**KIRKLEES METROPOLITAN COUNCIL
INVESTMENT & REGENERATION SERVICE**

DELEGATED DECISION TO DETERMINE PLANNING APPLICATIONS

Reference No:	2024/62/90538/W
Site Address:	Wood Crest, Stalley Royd Lane, Jackson Bridge, Holmfirth, HD9 7HX
Description:	Erection of two storey side extension, two storey rear extension and first floor balcony including associated works
Recommending Officer:	Lucy Taylor

Officer Report.

DRAWING TITLE
GA DRAWING - PROPOSED

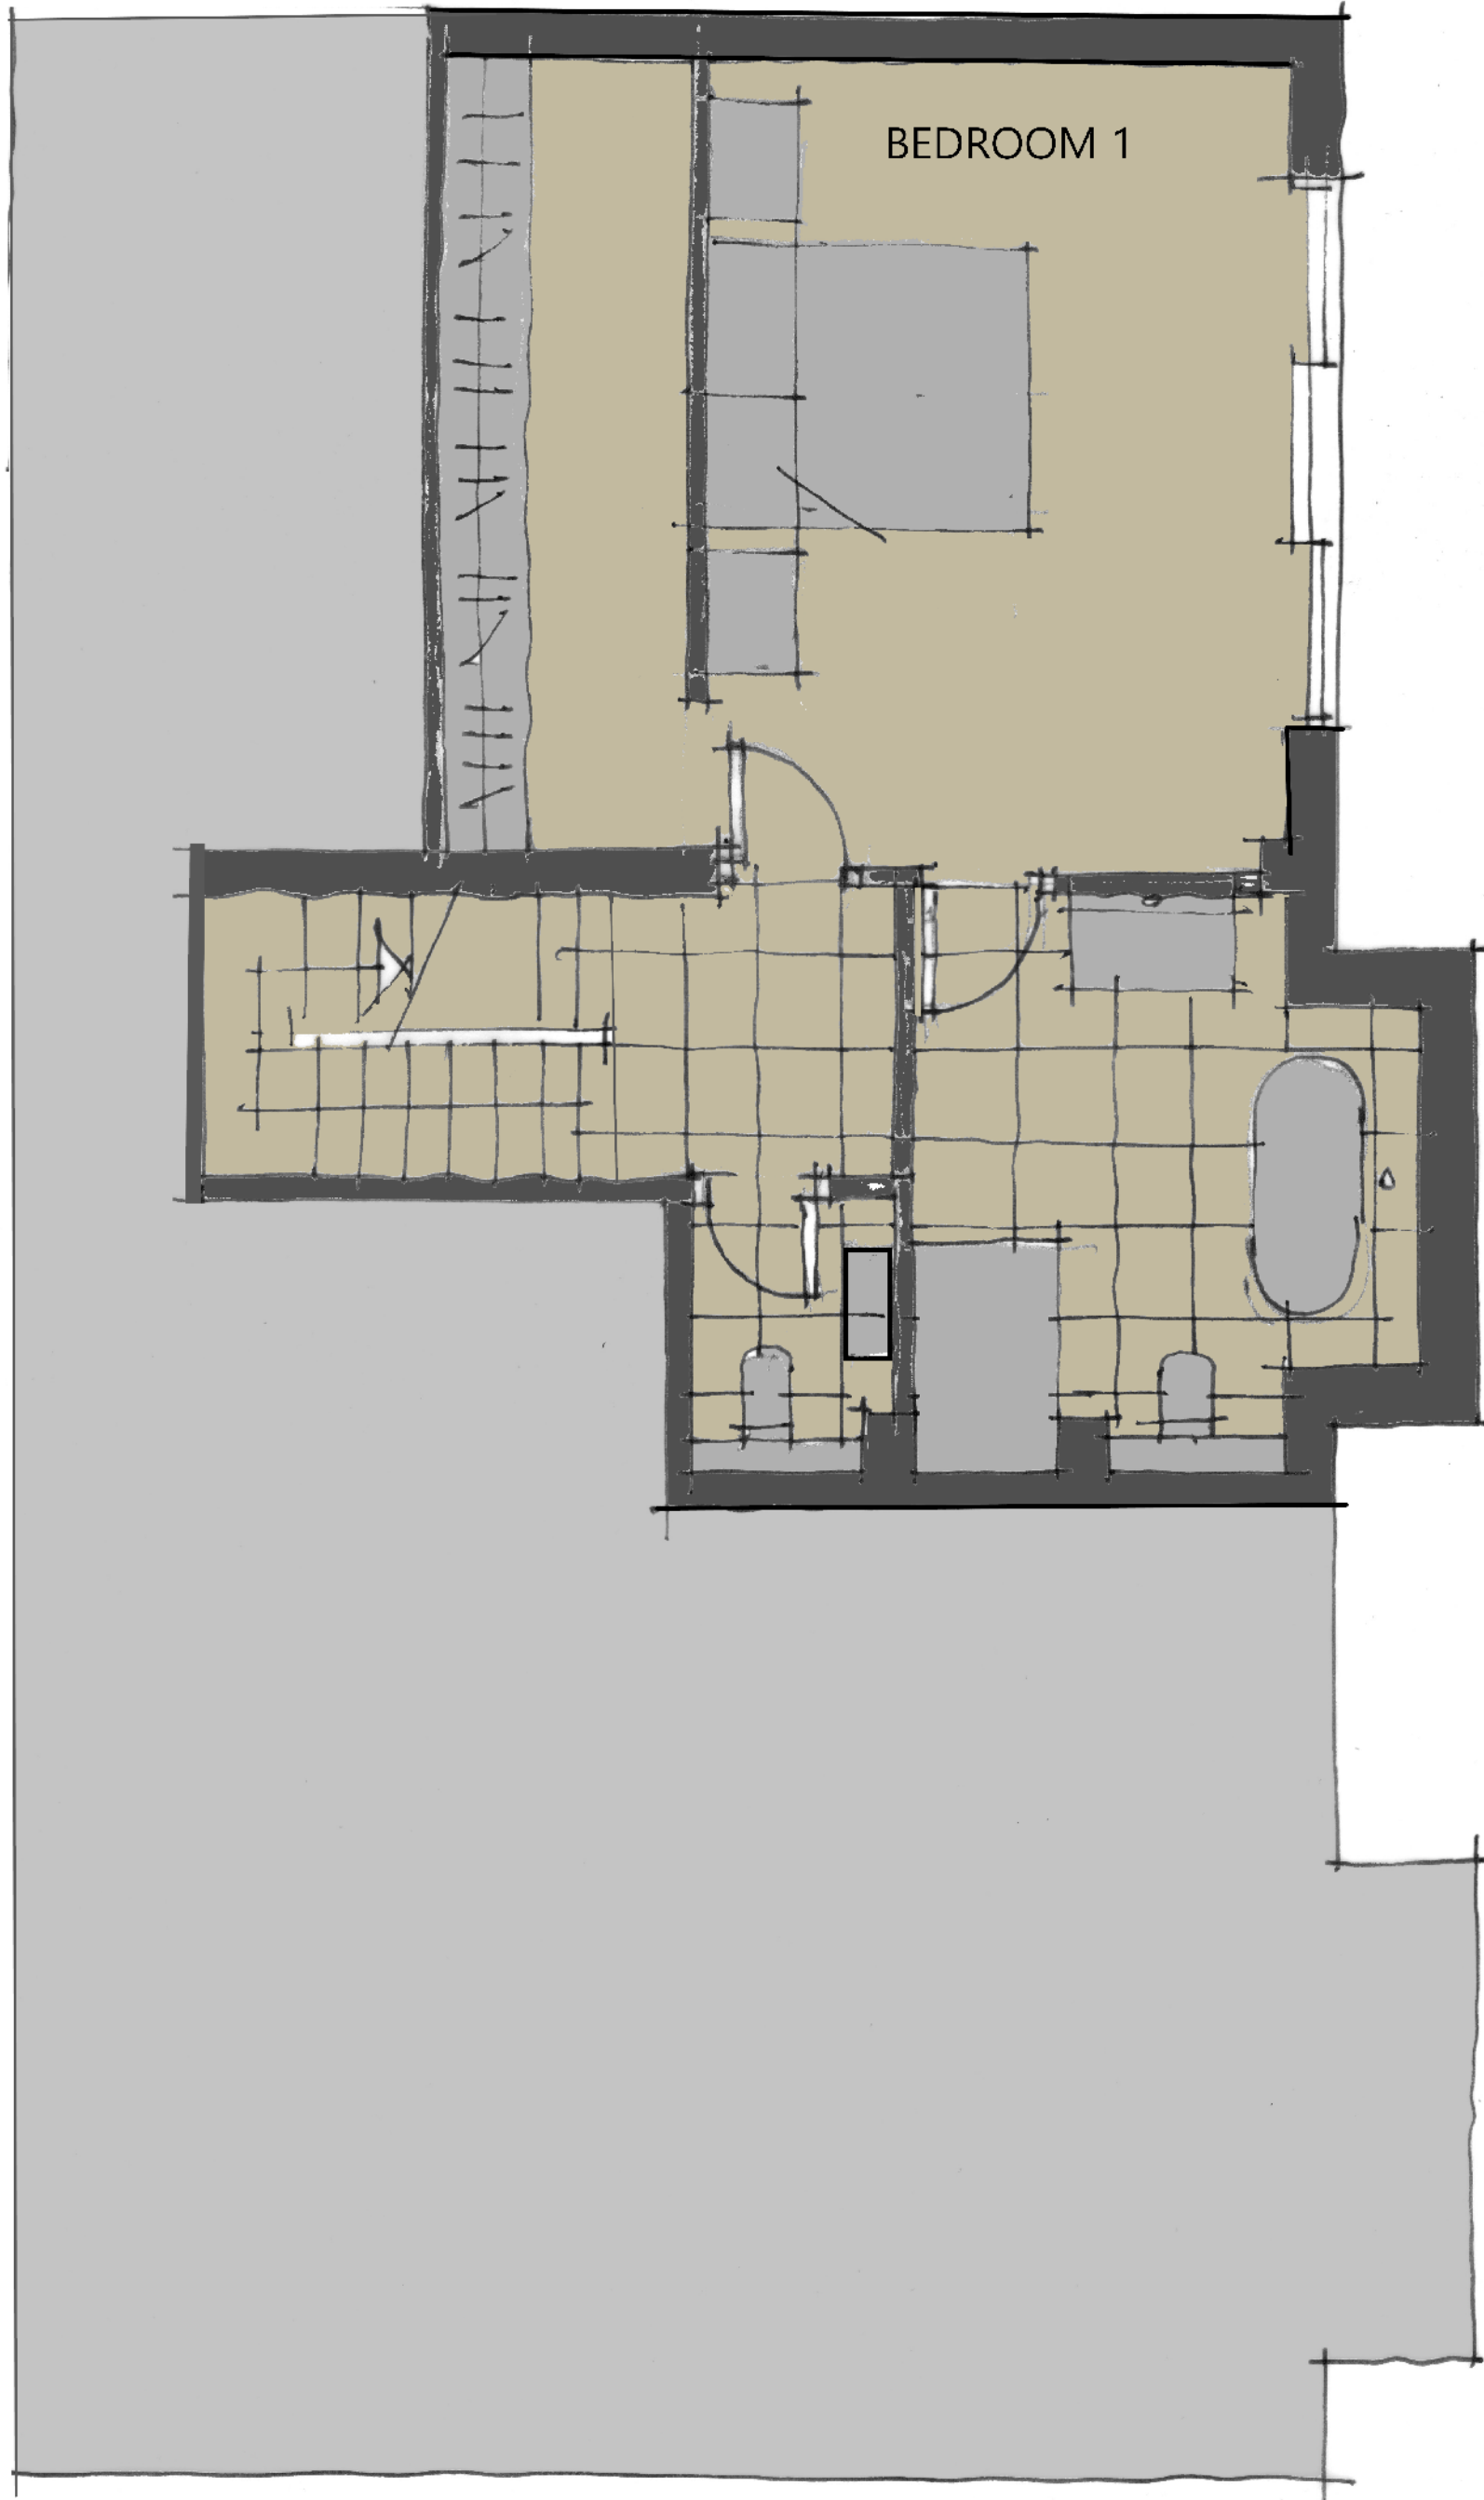
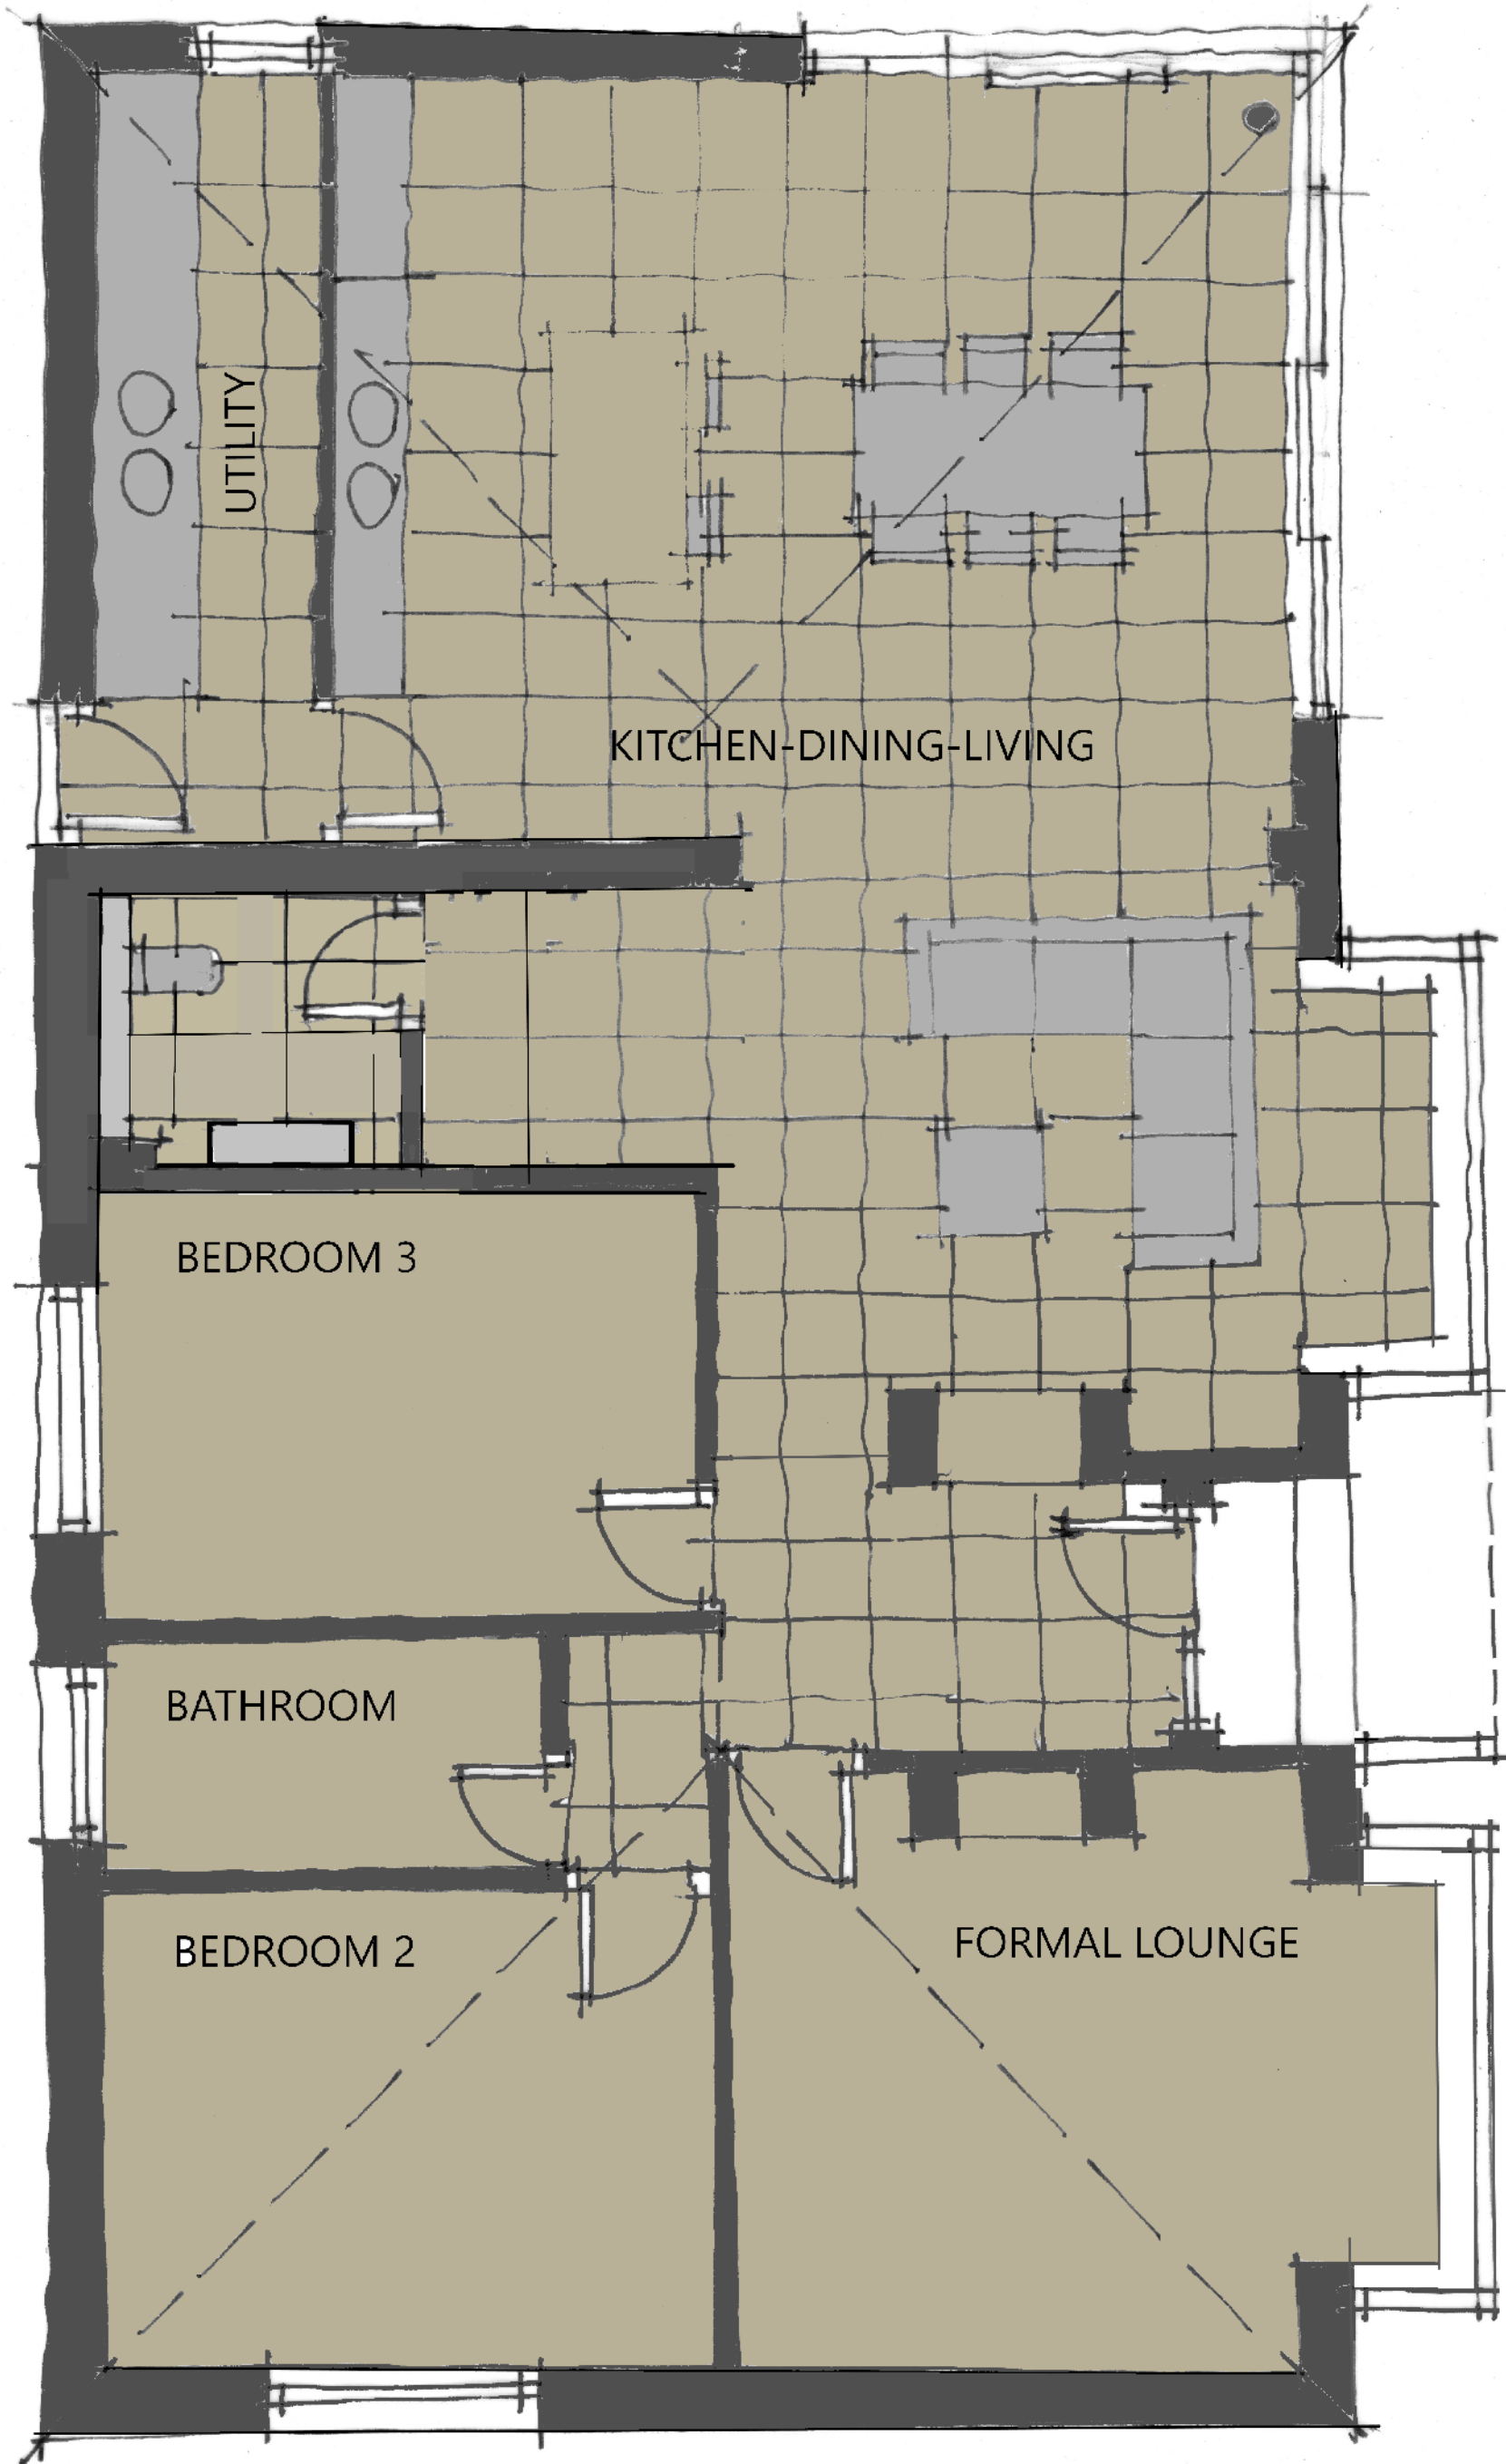
The volume of the resultant property, following the erection of the proposed extensions (including to the lower ground floor) would be approximately 680.39m². In turn, the proposal presents a percentage increase of approximately 58.57%.

As a consequence of the scale and mass proposed the development would represent inappropriate development within the Green Belt by reason of forming disproportionate additions to the original building. There would be additional other harm caused by development through a reduction in the openness of the Green Belt at the site by the formation of additional built form (spatial and visual harm).

The proposed extensions to Wood Crest are not considered to be subservient additions, creating an extension to the southern elevation of the host property, which would have the same ridge height as the host roof and would appear as two-stories in height when viewed from the wider streetscene, with a visible and fenestrated elevation created at lower ground floor level. As well as appearing as dominate within the immediate context of the site, it is also considered that the extension would be out of keeping with the character of its immediate setting, with the properties adjacent along Stalley Royd Lane bungalows in their construction style.

It is also considered that the application of timber to the external walls of the extension would be out of keeping with the character of the property and with the wider character of the area. As well as this, it is considered that the vast extent of glazing and raised balcony proposed to the principal elevation would appear at odds with the architectural design of the host property and properties within the immediate vicinity, with are relatively tradition in terms of fenestration to the principal elevation been limited to regular windows.
